KIRKLEES METROPOLITAN COUNCIL INVESTMENT & REGENERATION SERVICE

DELEGATED DECISION TO DETERMINE PLANNING APPLICATIONS

Reference No:	2023/62/92452/E
Site Address:	173, Foxroyd Lane, Thornhill, Dewsbury, WF12 0LT
Description:	Erection of garage
Recommending Officer:	Elenya Jackson

PROPOSED PART FRONT ELEVATION

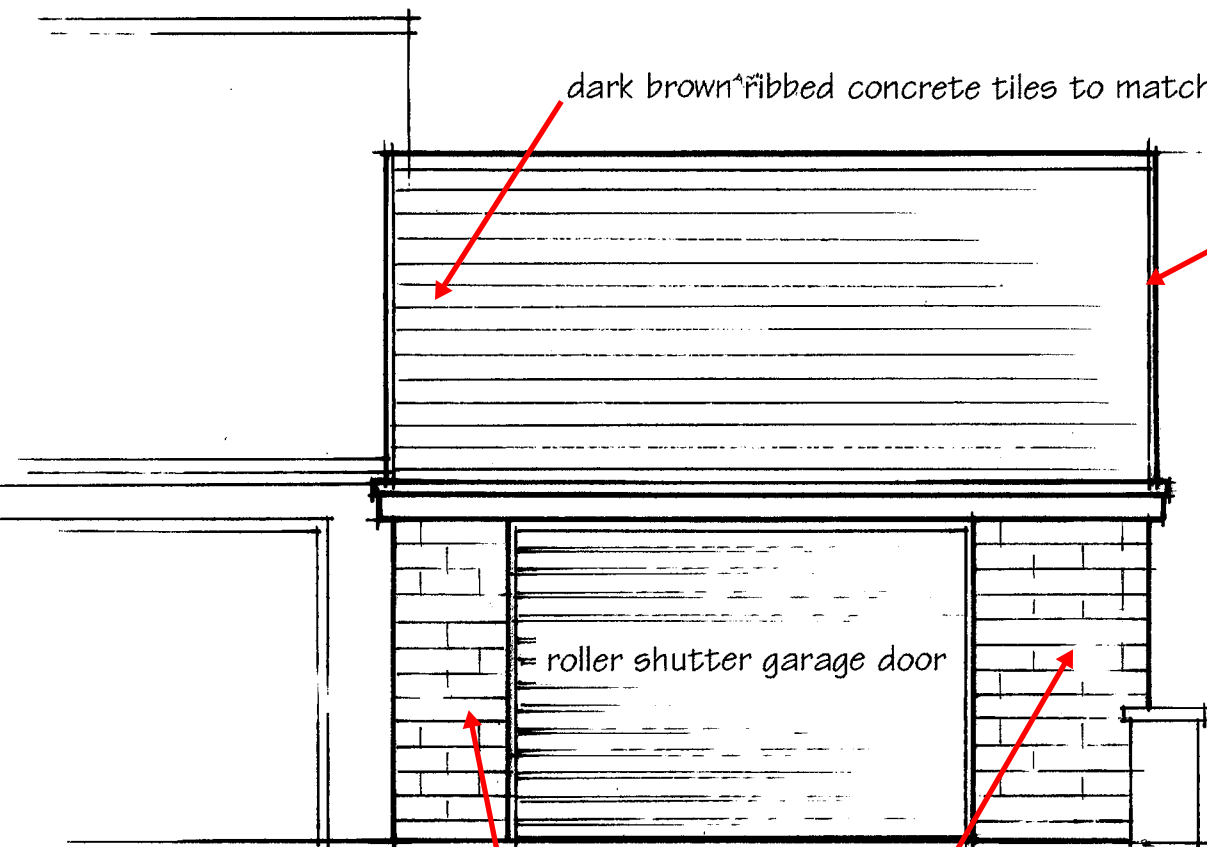
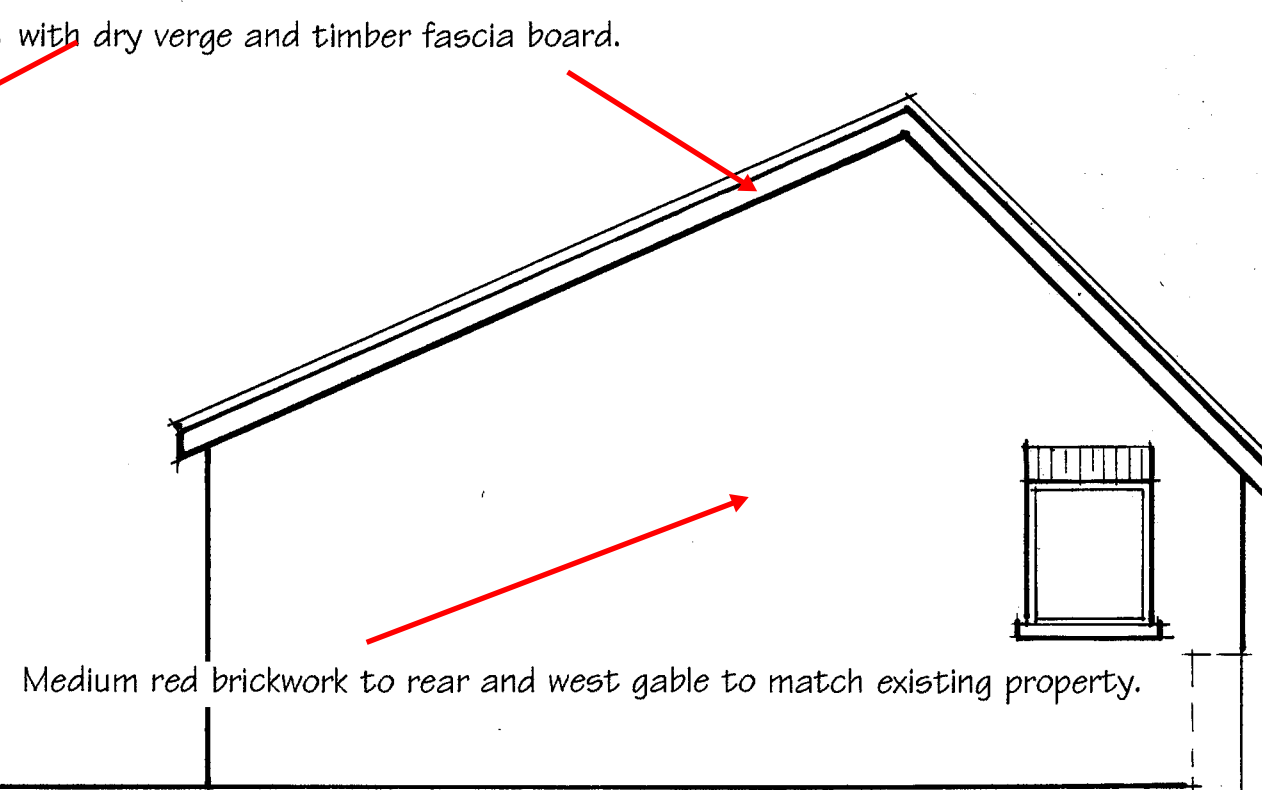
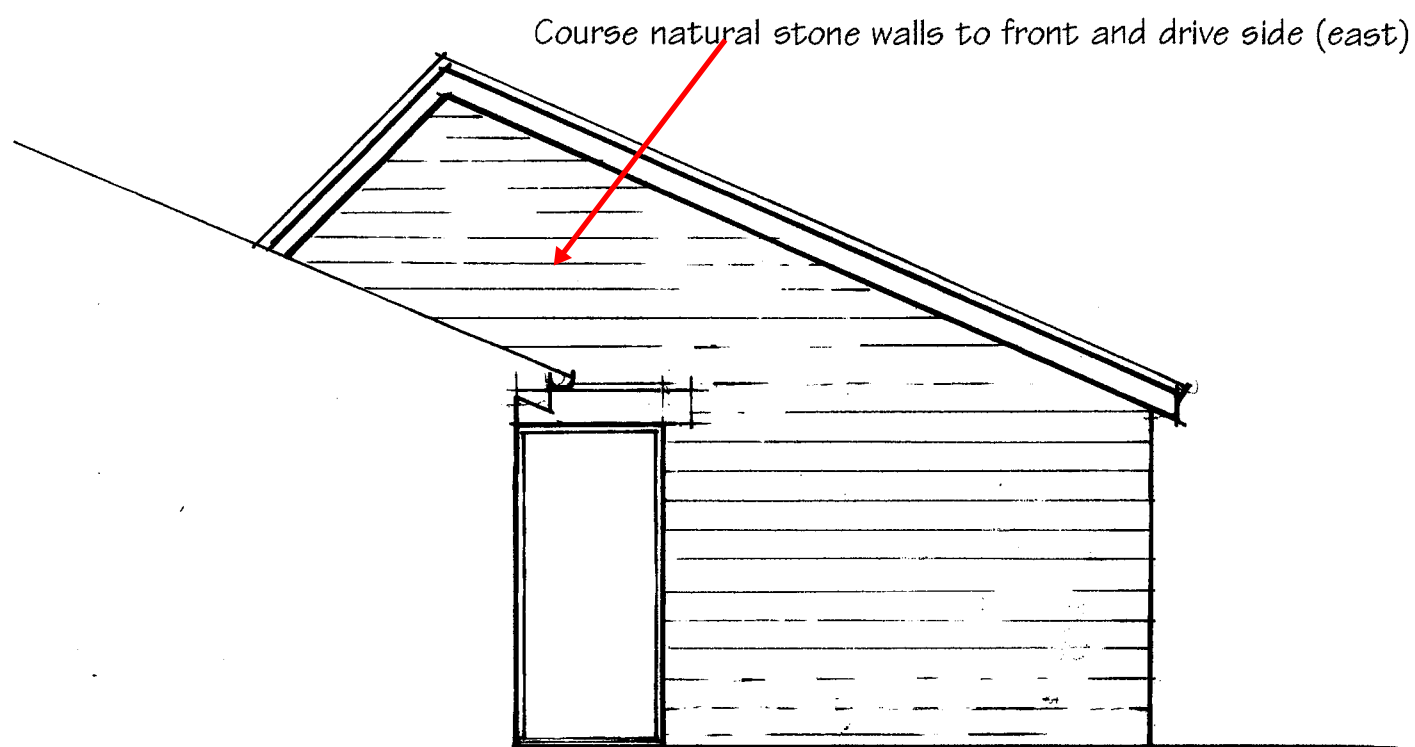
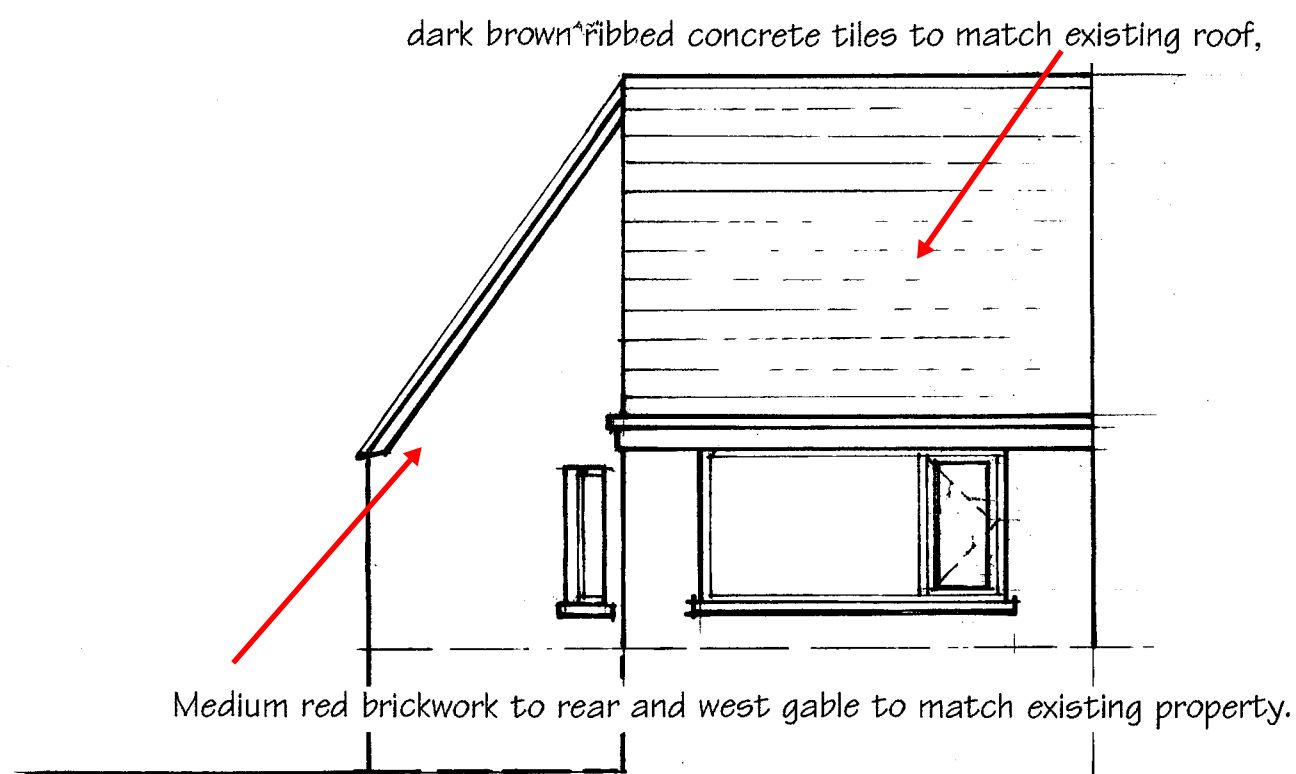
Officers initially raised concerns regarding the depth of the proposal in relation to the host dwelling. The agent subsequently provided additional information to justify the proposal in relation to the context of the area (the proposal would not project beyond the building line to the west). In addition, they have provided an amended plan which shows an amended roof pitch and subsequent reduction in overall height.
